# **traffic impact assessment;**

**Nepean Hospital - Stage 2  
Development (SSD-16928008)**

For Health Infrastructure

15 December 2021

Attachment 1 – Western Loading Dock Swept Paths

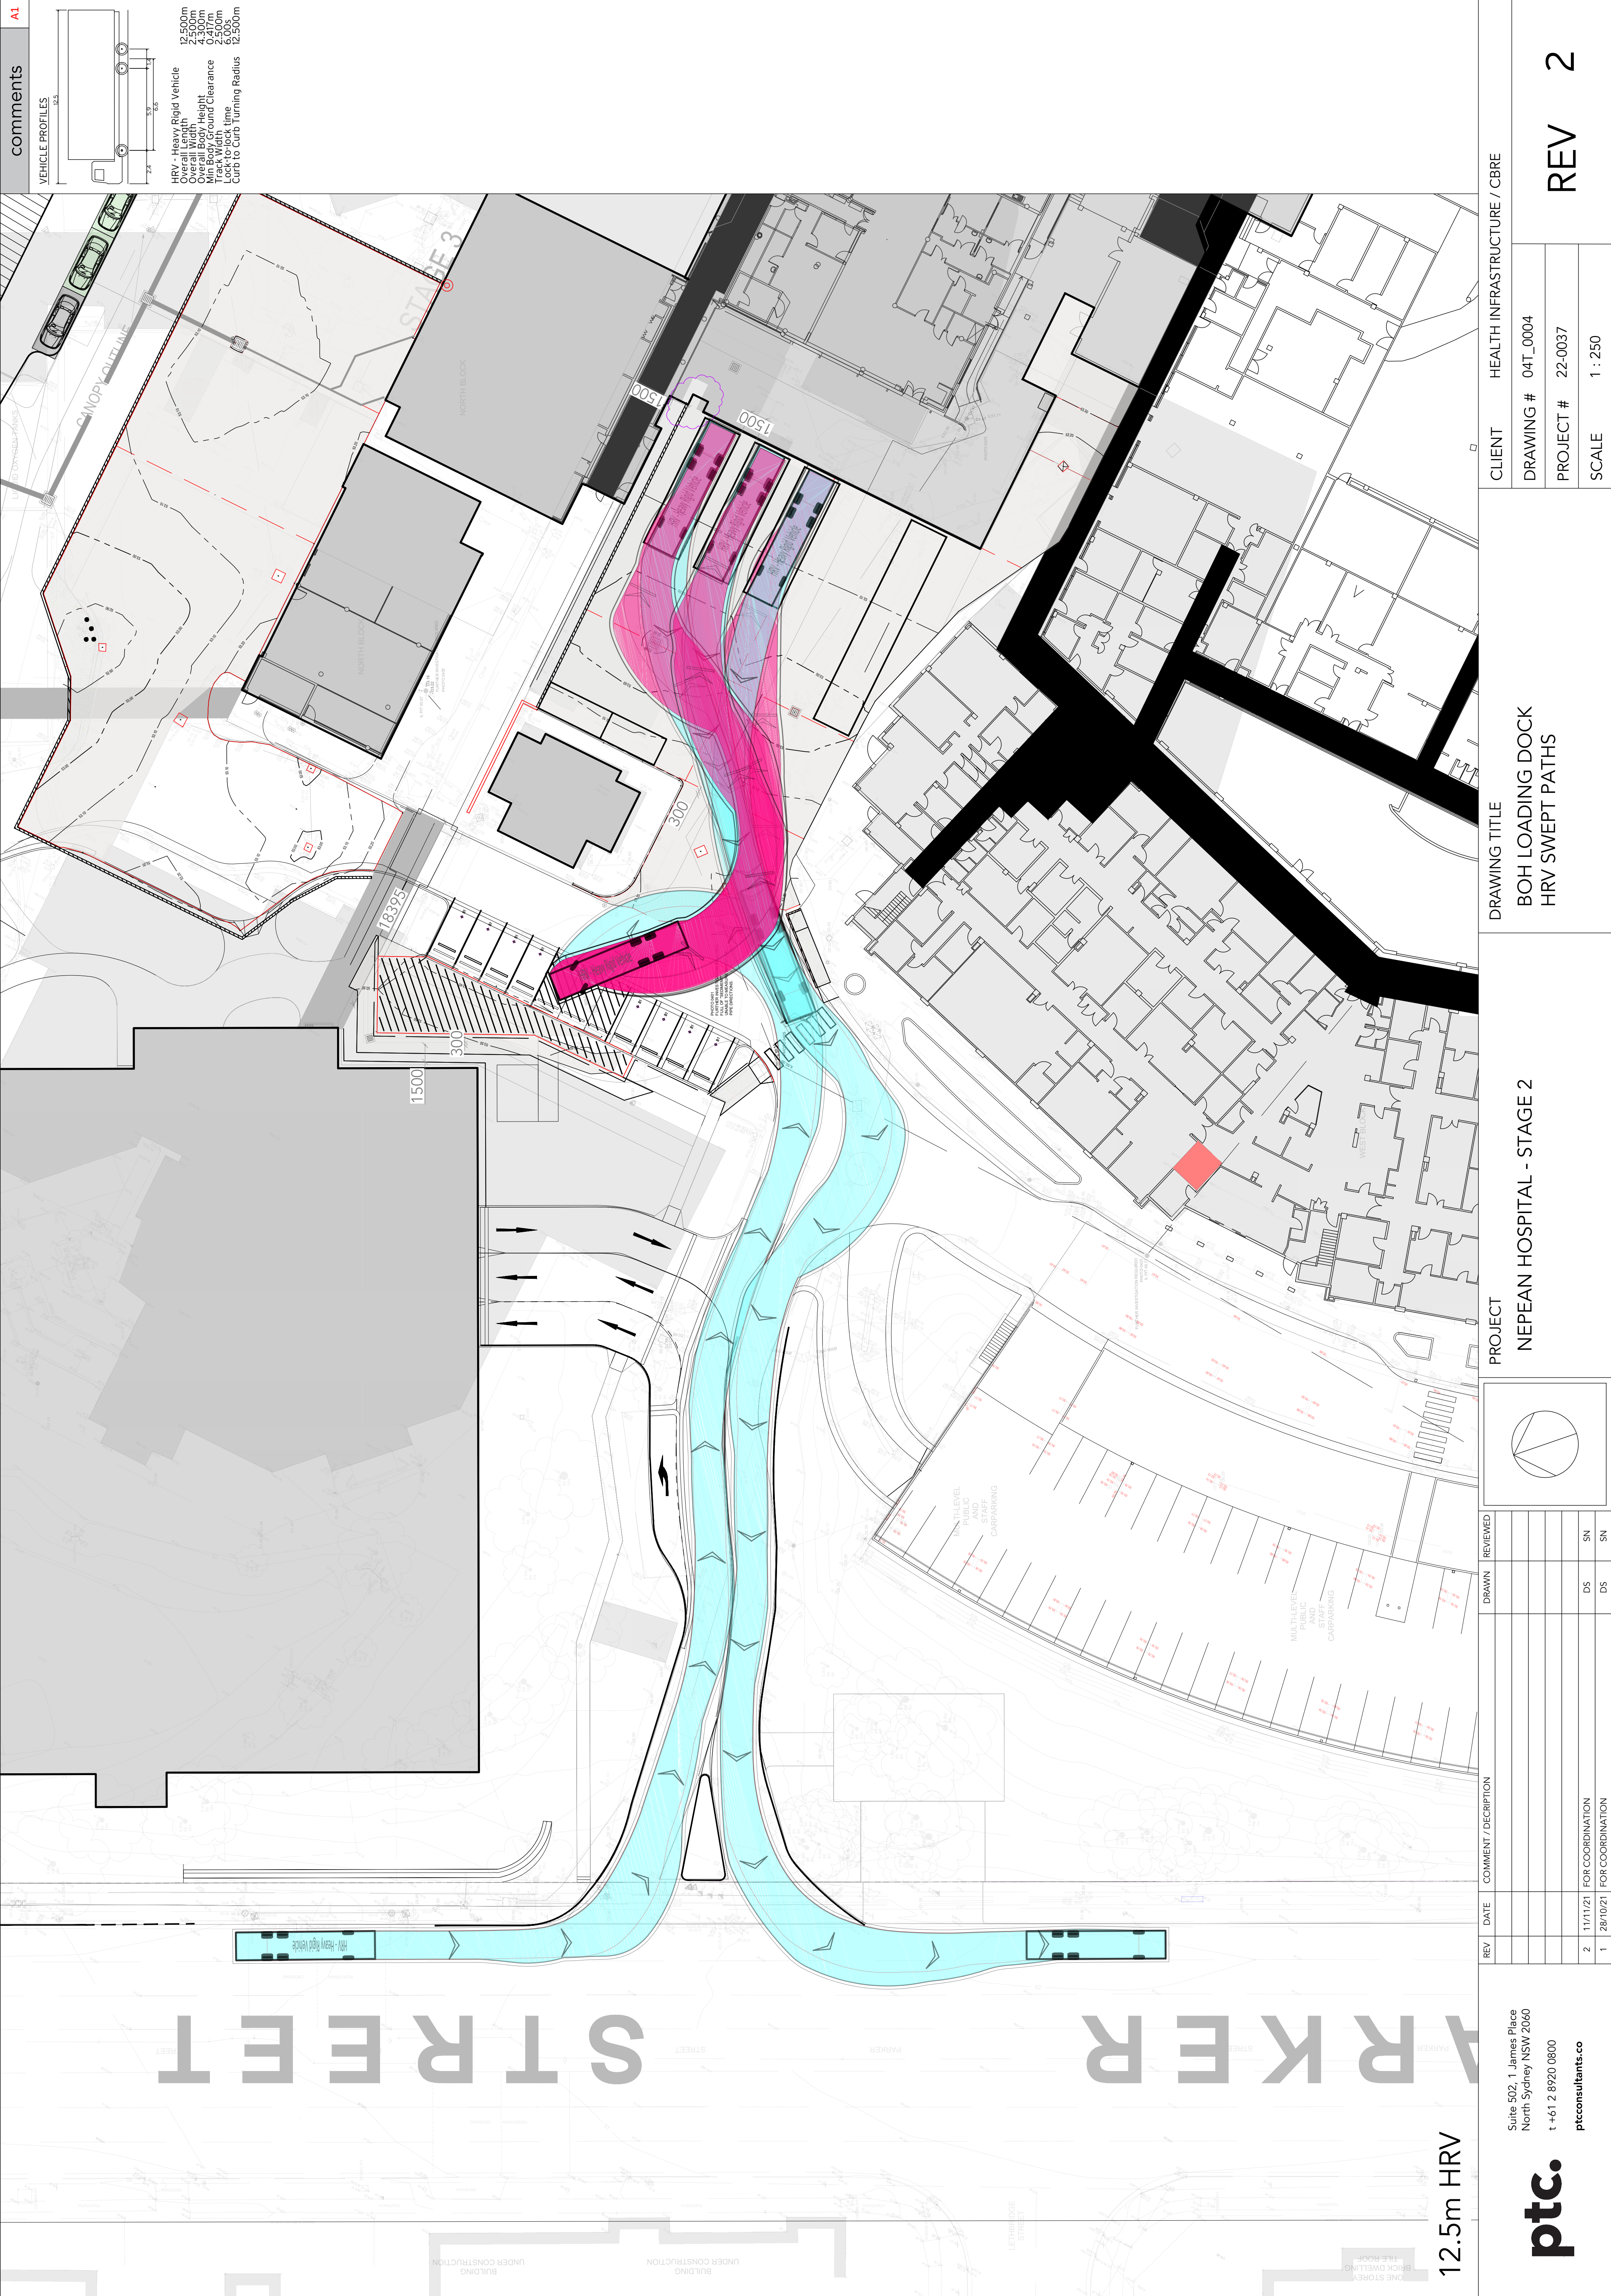
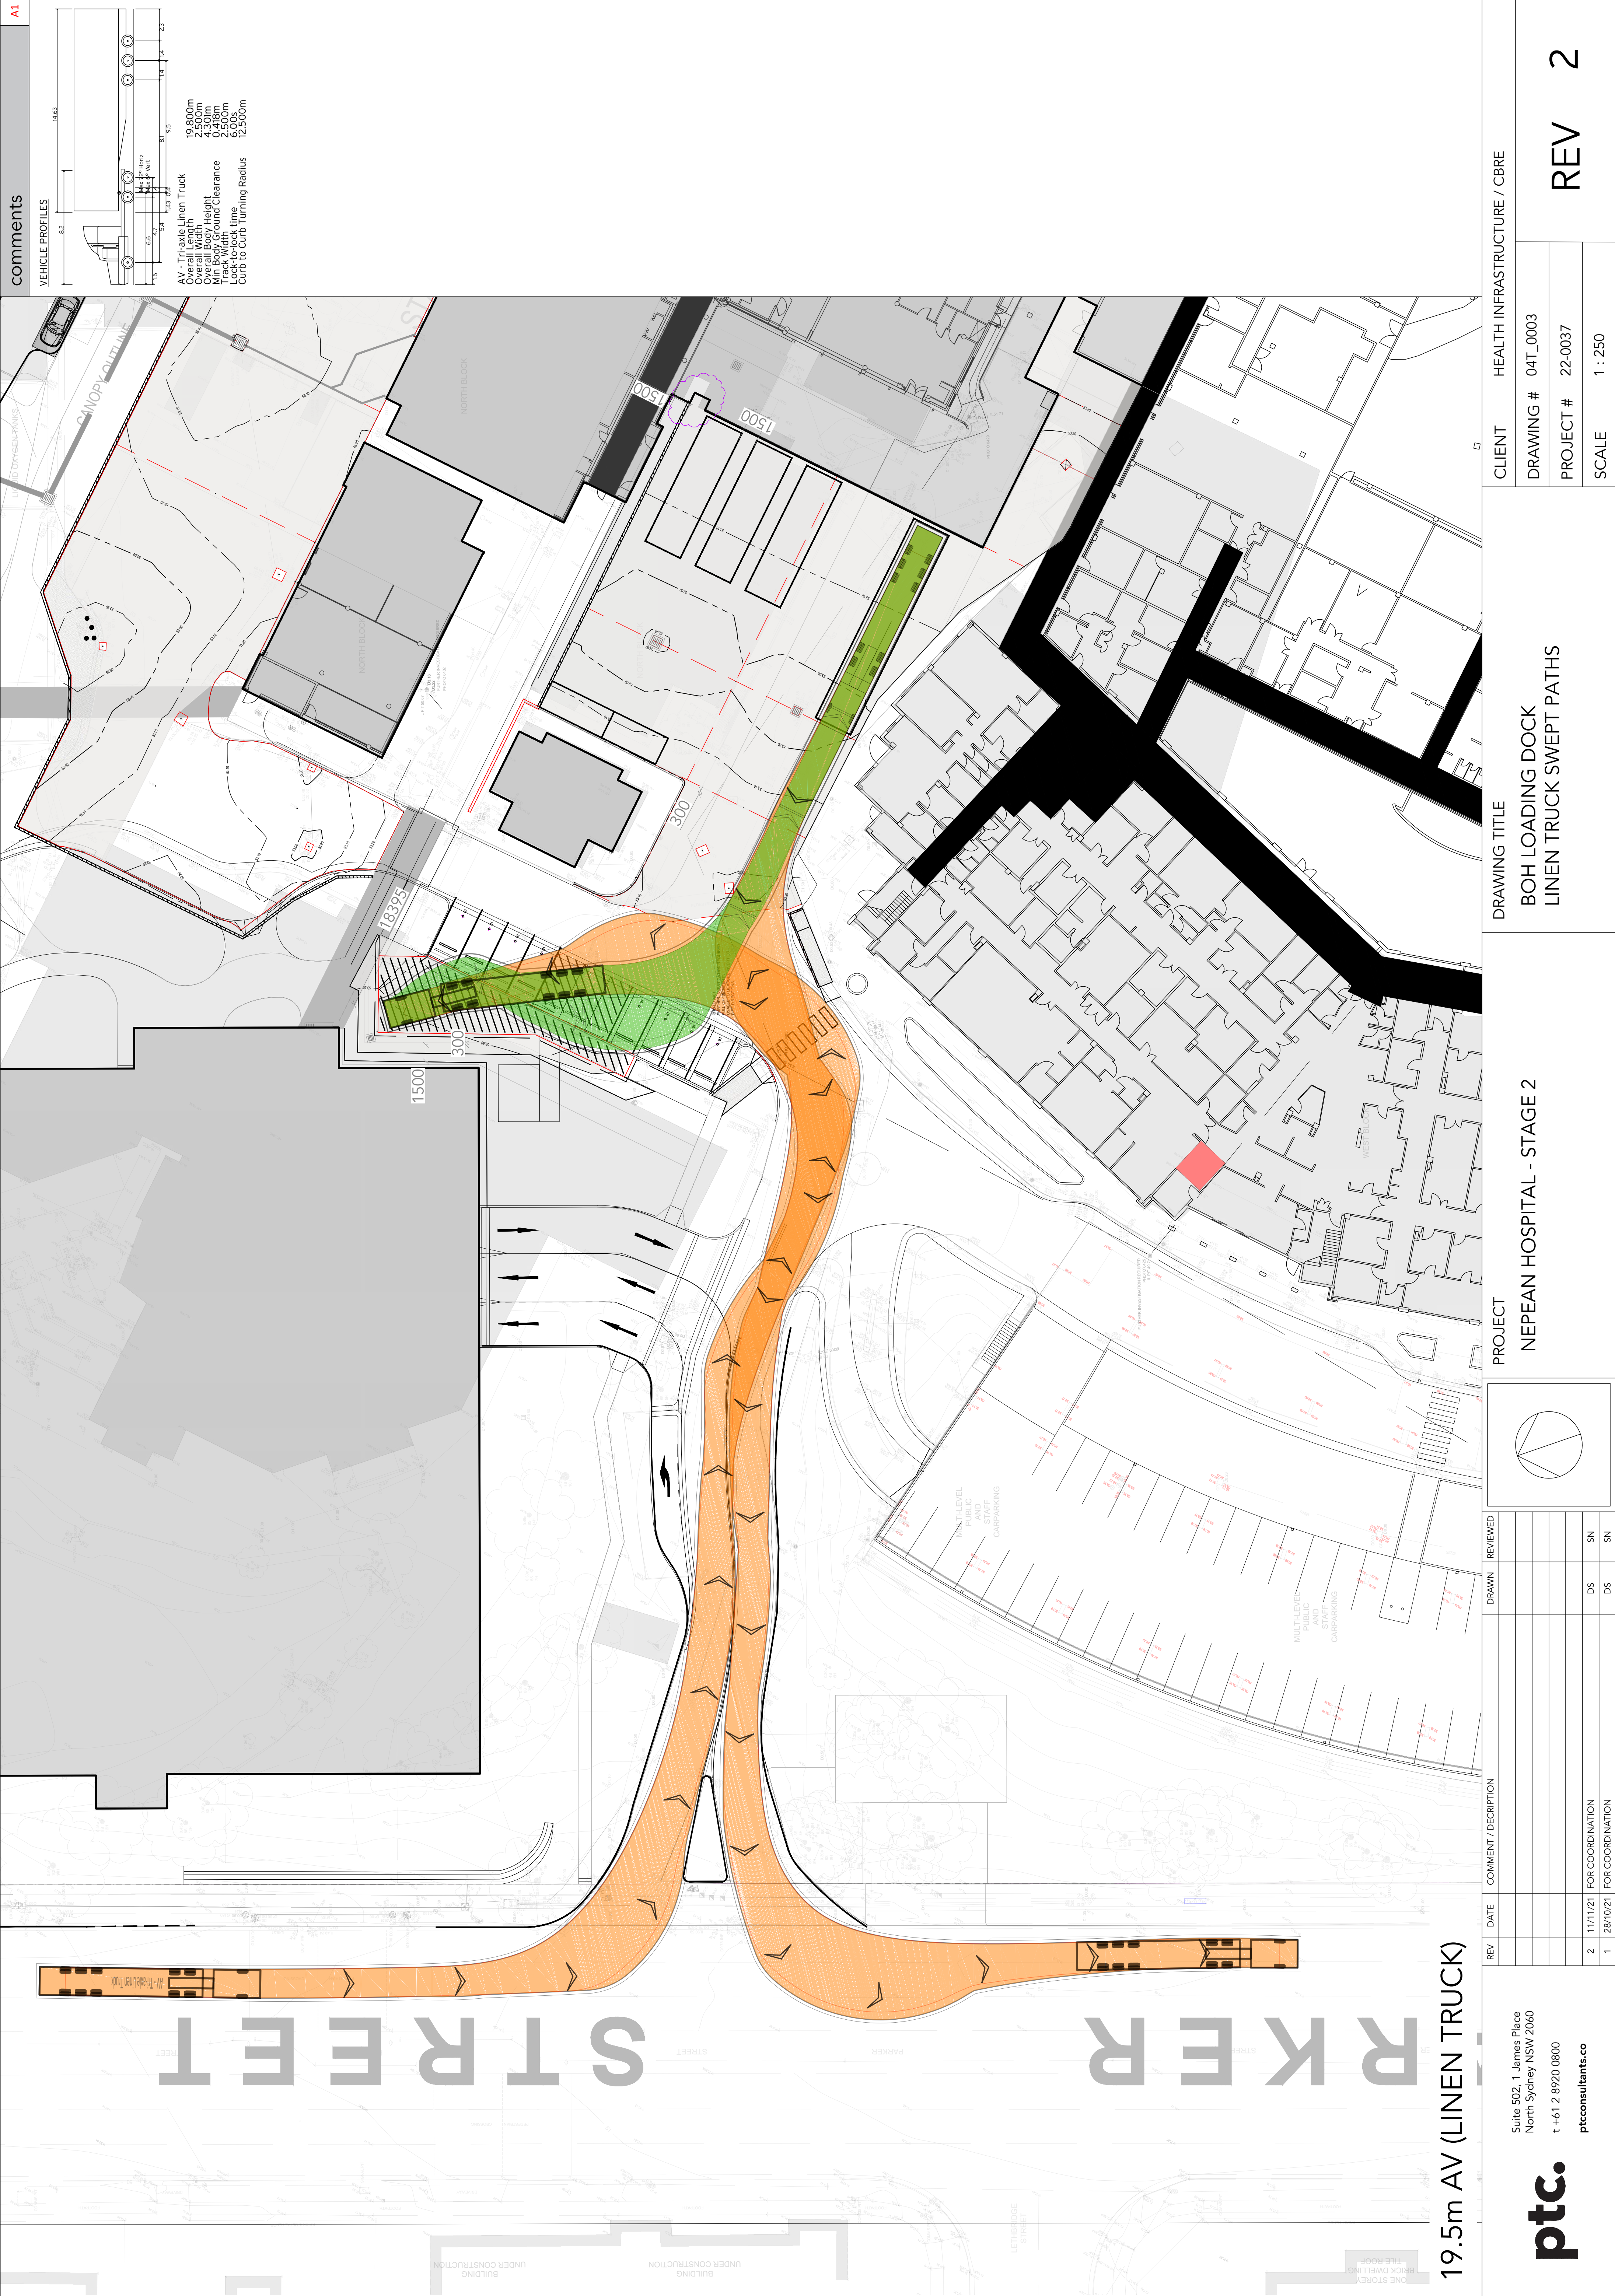
*i. Drawing #04T\_0004 – HRV reversing swept path indicates that truck will encroach into adjacent parking spot of hatched area. A parked vehicle would obstruct trucks ability to reverse into loading bay;*

The swept path has been adjusted to remain within the hatched area

*ii. Drawing #04T\_0003 – Linen truck swept path appears to track over parking spaces – how will these spaces be kept empty to ensure that truck has clear swept path?*

- *Truck appears to turn from lane 2 on Parker St, truck should be straddling lanes 1 and 2 to ensure no vehicles can occupy lane 1 as vehicle turns left into Barber St*
- *Truck appears to use opposing traffic lane on Barber St upon entry – how is this safely being managed?*

The layout has been designed to accommodate an articulated linen truck in the case that this type of vehicle is used in lieu of the Heavy Rigid Vehicle typically used. Noting that the current linen supplier (Healthshare) does not use articulated vehicles, but have requested that the design allow for these vehicle in case of operational changes. In this situation, these parking spaces will be closed for use on days when the articulated linen truck is planned to access the loading dock.

The swept paths have been revised to demonstrate the articulated vehicle straddling lanes 1 and 2.  It is proposed to retain the existing Derby Street carriageway, which has provided access to the loading dock without incident as there are passing opportunities and clear sight lines along the route.
